CITY OF ALBUQUERQUE
Planning Department
Development Review Board Case Comments
1/29/03

Project# 1002427

Case # 03DRB-00069

Subject: Panorama Addition.

**SKETCH PLAT OF
LOTS 31-A & 31-B, BLOCK 3
PANORAMA ADDITION
SITUATE WITHIN SECTION 22 ,
T. 10 N., R. 4 E., N.M.P.M.
CITY OF ALBUQUERQUE
BERNALILLO COUNTY, NEW MEXICO
JANUARY, 2003**

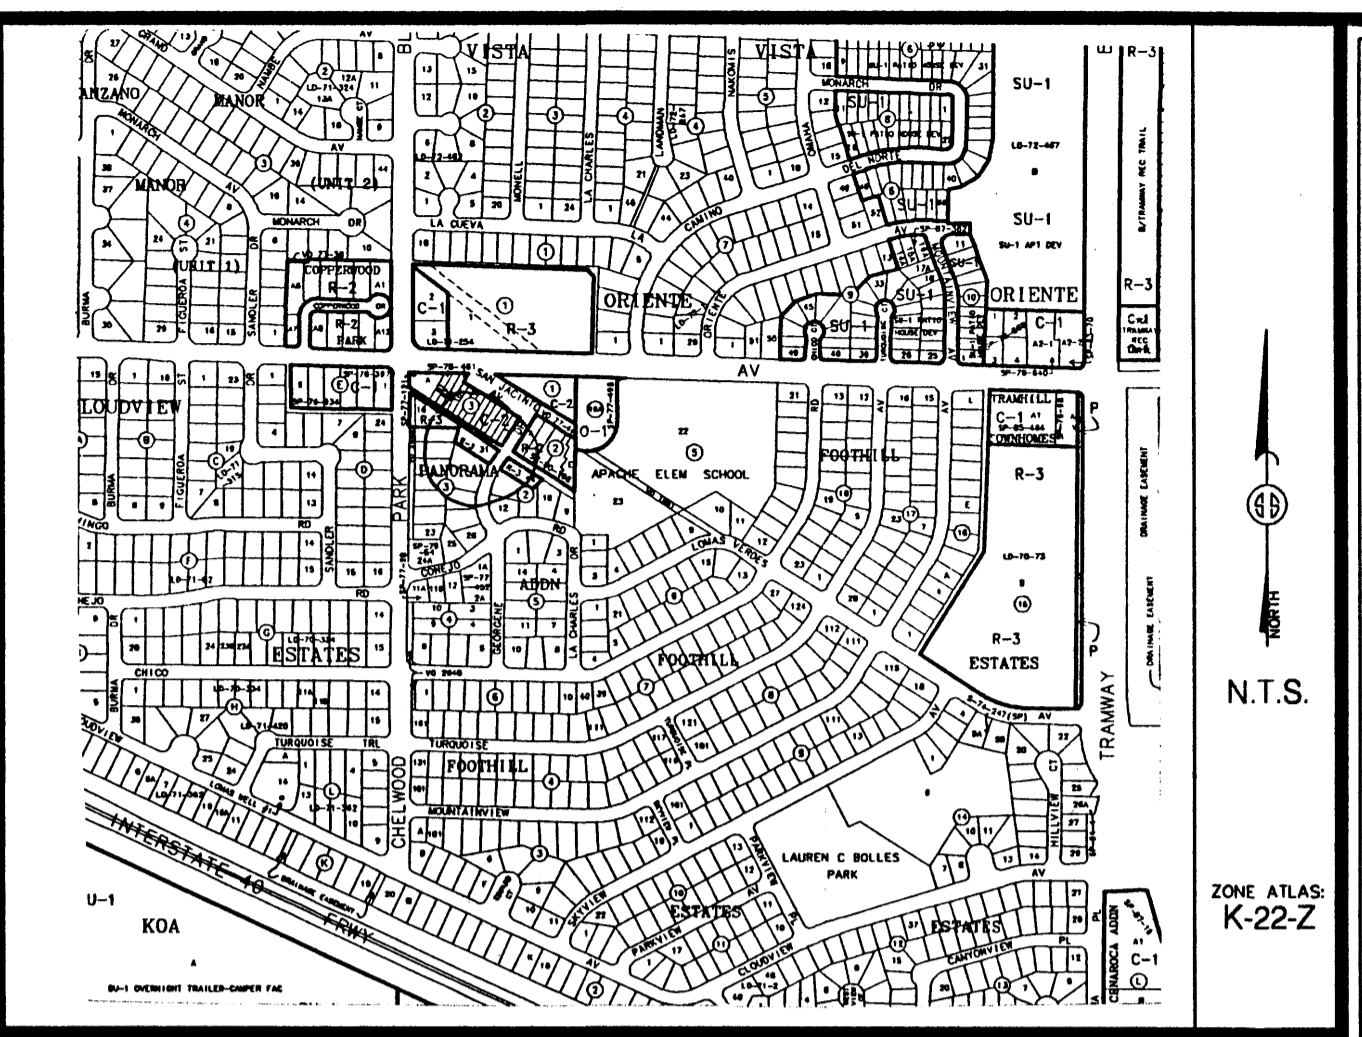
How many apartments are planned?

The minimum lot size for R-3 zoning is 150' wide & 150' deep. This lot is only 60' deep. The Zone Code states that, for its non-conforming to these minimum lot dimensions, RT zone regulations may be applied in all aspects. This means only townhouses or single family residential is permitted or conditional uses in R-1 zoning. R-1 does not allow apartments either.

Is the alley paved?
 Cross-lot drainage easement may be required.

Are the apartment buildings existing. If they are no park dedication fee will be required. If they do not exist cash in lieu for 1 lot will be required to meet the park dedication requirement.

No.	Comment
<input type="checkbox"/>	Is the alley paved?
<input type="checkbox"/>	Cross-access easements will be needed.
